## NSW RURAL FIRE SERVICE

Your Ref: SSD 8643  
Our Ref: D18/386  
DA18012411516 AB

**Agency Comment: Sapphire Solar Farm (SSD 8643) Environmental Impact Statement Exhibition;  
Gwydir Highway Kings Plains Inverell LGA**

Figure 2-4: Sapphire Solar Farm Site Plan

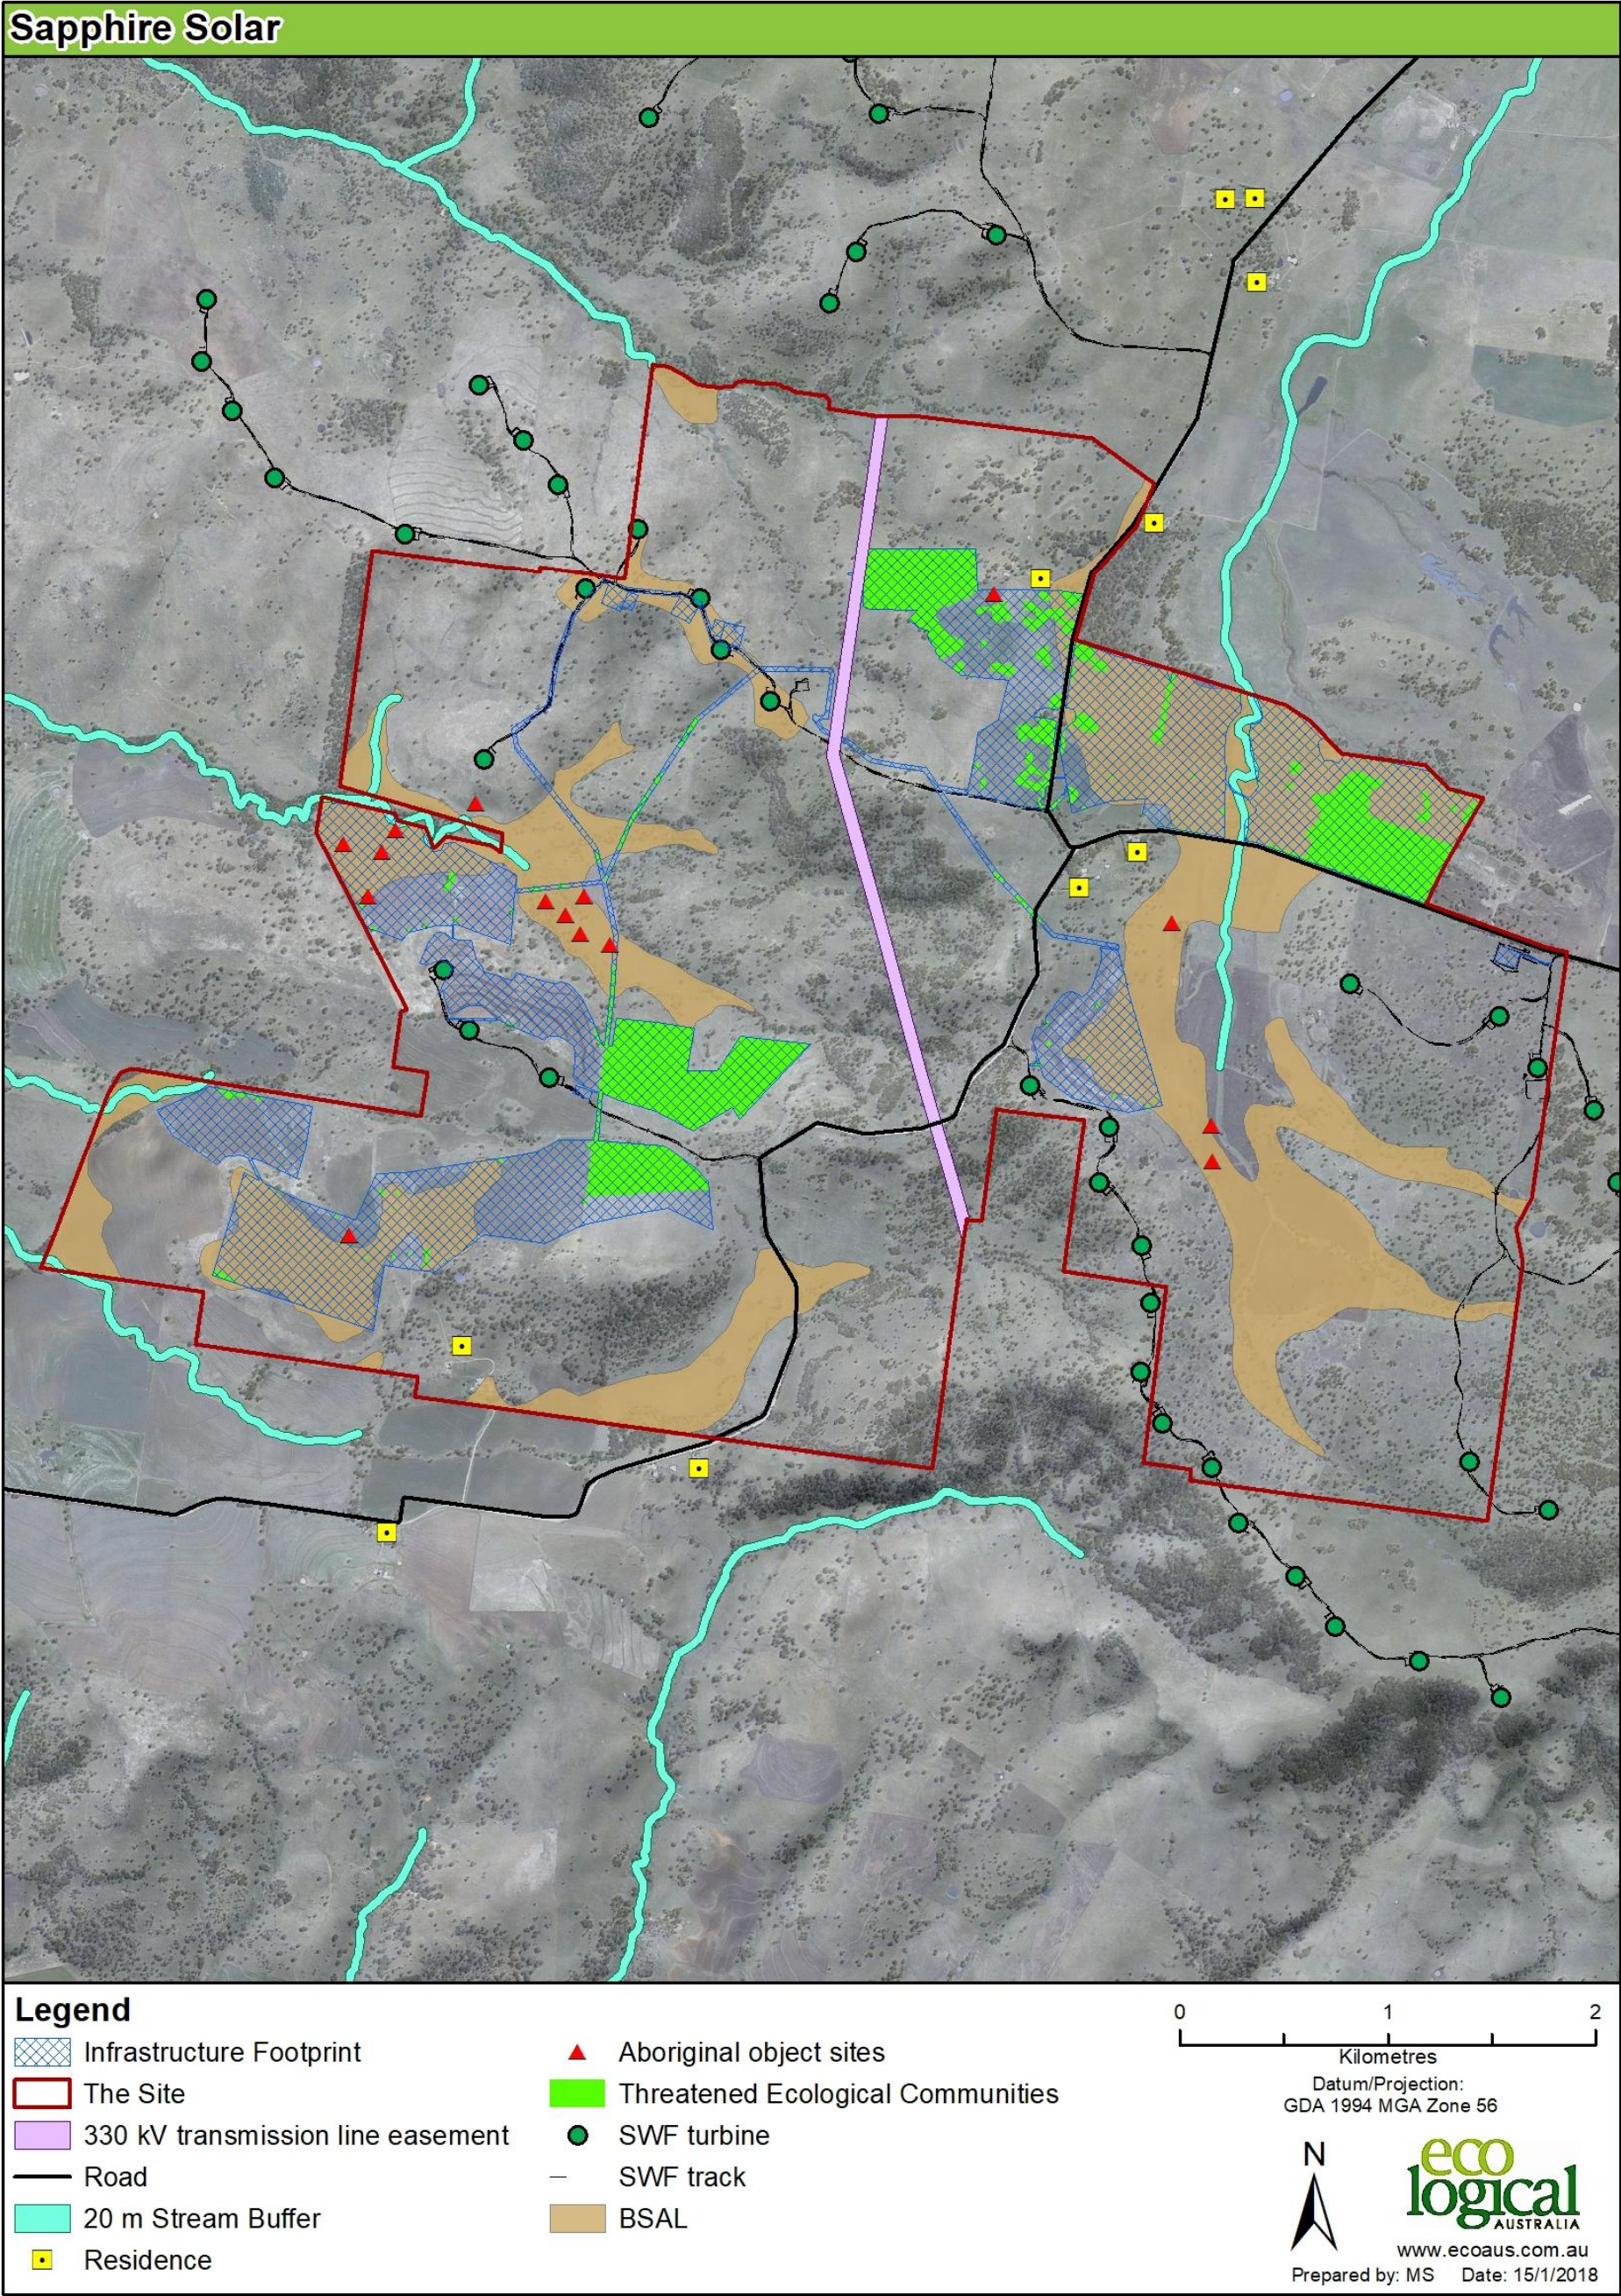
The Environmental Impact Statement (EIS) does not adequately address the bush fire impacts of the proposed development. The EIS does not provide any relationship between the array/infrastructure sites and the bush fire prone land mapping or any relationship between the array/infrastructure sites and the landscape including vegetation. The EIS provides no detail off bush fire impacts or suitable bush fire protection measures. The constraints mapping does not include bush fire hazards.

The EIS shall be amended to show these relationships and provide suitable trafficable defensible space, based on vegetation communities and effective slope. Such calculations would identify flame length and radiant heat exposure around each array site and proposed defensible space. The EIS shall also identify the extent of proposed land management practices to achieve suitable separation distance between the identified bush fire hazard (including grasslands) and the proposed array/infrastructure sites.

The EIS shall provide a detailed plan of the internal road access network for fire fighting vehicles around each array/infrastructure site and between each array/infrastructure site. Further, the EIS shall provide detail for the location of water supplies for suitable fire fighting response to each array/infrastructure site.
